**CITY OF PORTLAND, MAINE
DEVELOPMENT REVIEW APPLICATION
PLANNING DEPARTMENT PROCESSING FORM**

2002-0236
Application I. D. Number
10/30/2002
Application Date

50 Tide Mill Road (Lot # 5)
Project Name/Description

Approval Conditions of DRC

SITE PLAN	
CLOUTIER CONSTRUCTION	
TIDE MILL ROAD	
PORTLAND, MAINE	
CLOUTIER CONSTRUCTION	
HERBERT P. GRAY	
111 SIMONS ROAD, SOUTH PORTLAND, MAINE 04106	
SCALE: 1"=20'	DWG. NO. 1
DATE: 10/24/02	
DRAWN BY: HPG	
CHECKED BY: HPG

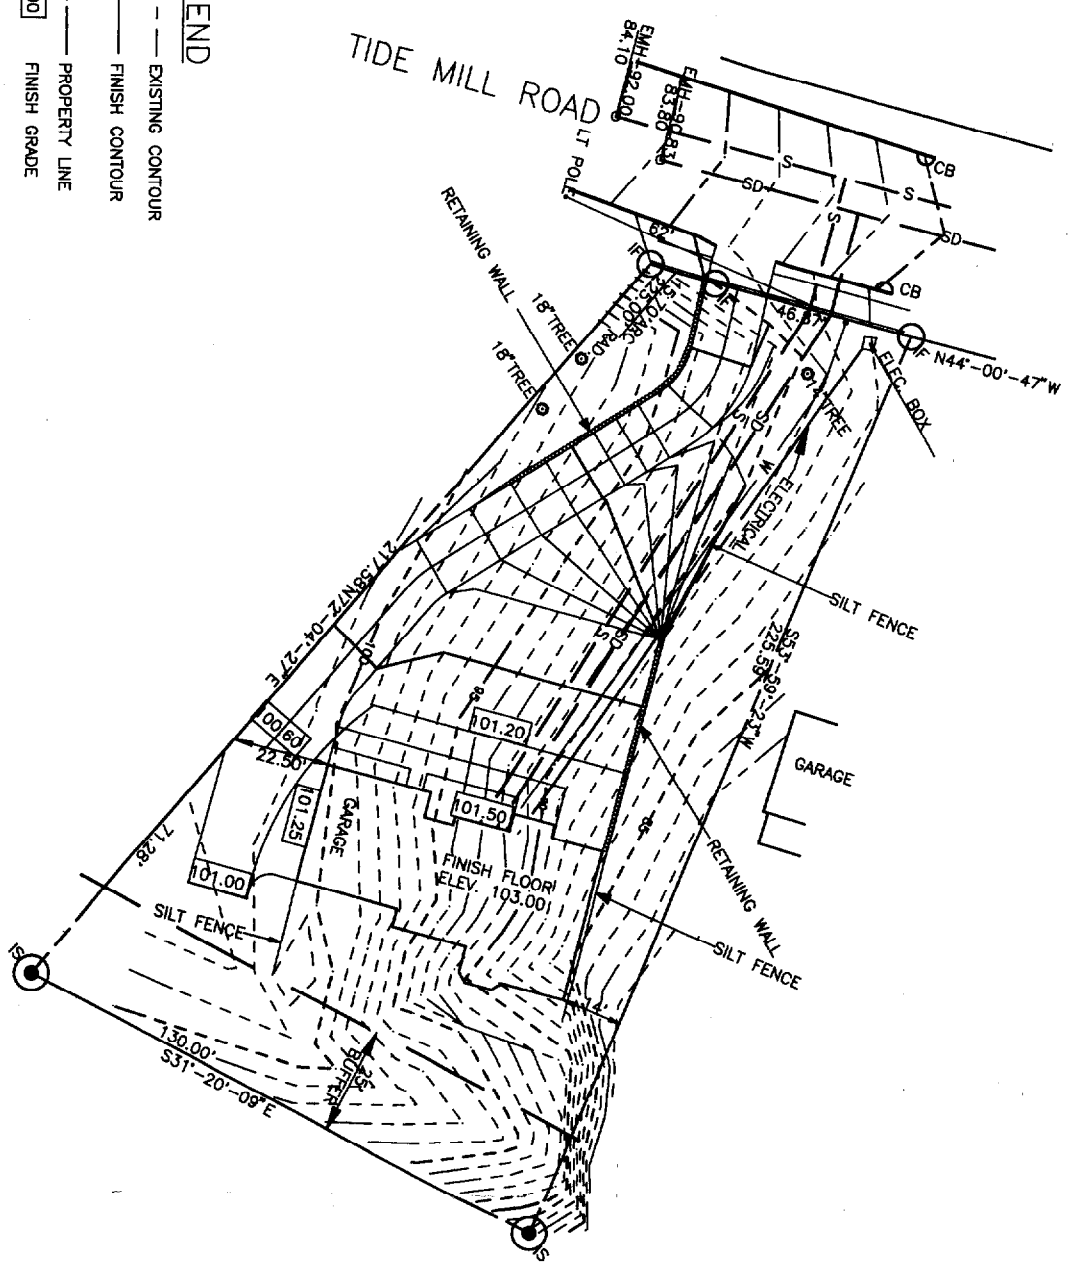
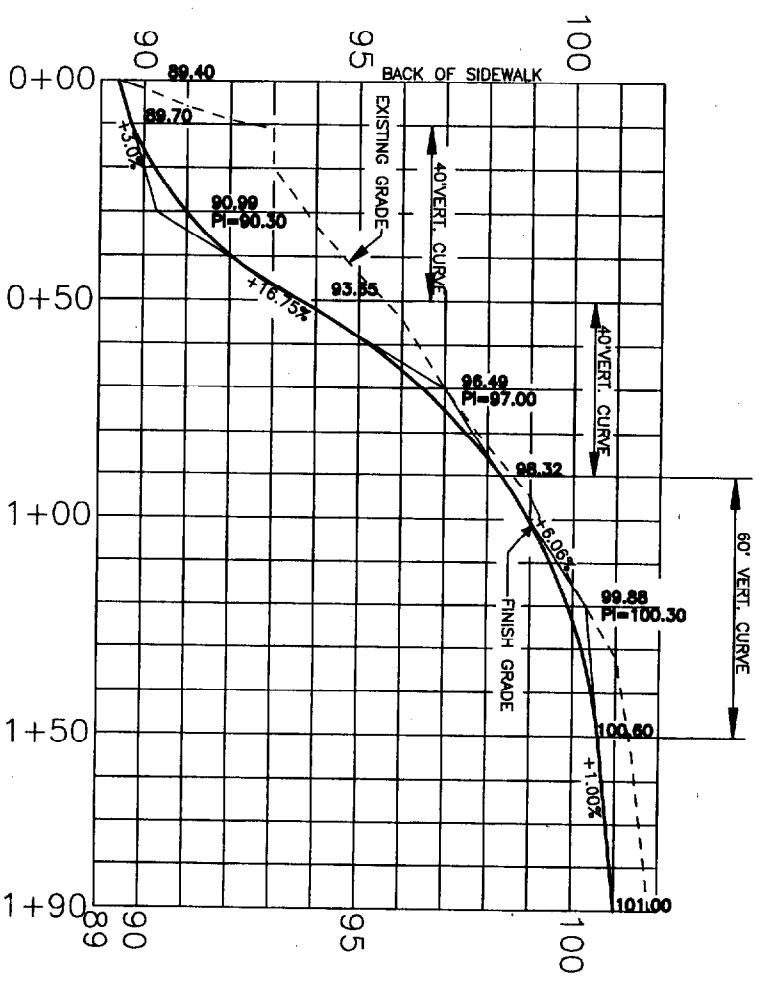
Follow topo, no any lines!
** No Core Classes on both east and both side?*
** What's RFE?*
** Lead Contam on S and SD*
** Roll Permit away from R*
** Lead Railings Along with of over 4'*

- 1 GUARD RAILS WILL BE REQUIRED (PER BOCA CODE) ALONG THE THREE RETAINING WALLS.
- 2 CLEANOUTS MUST BE INSTALLED ON THE SANITARY AND STORM DRAIN LATERALS (PER CODE), WITHIN 80 FEET FROM THE MAIN LINES OF EACH UTILITY.

- 9 The site contractor shall establish finish grades at the foundation, bulkhead and basement windows to be in conformance with the first floor elevation (FFE) and sill elevation (SE) set by the building contractor to provide for positive drainage away from entire footprint of building.

11-13 Revised Plans
** Final Topo*
** RFE*
** RFE will Be*

*11-14 *Condition Guard Rails*
**Condition Concrete*
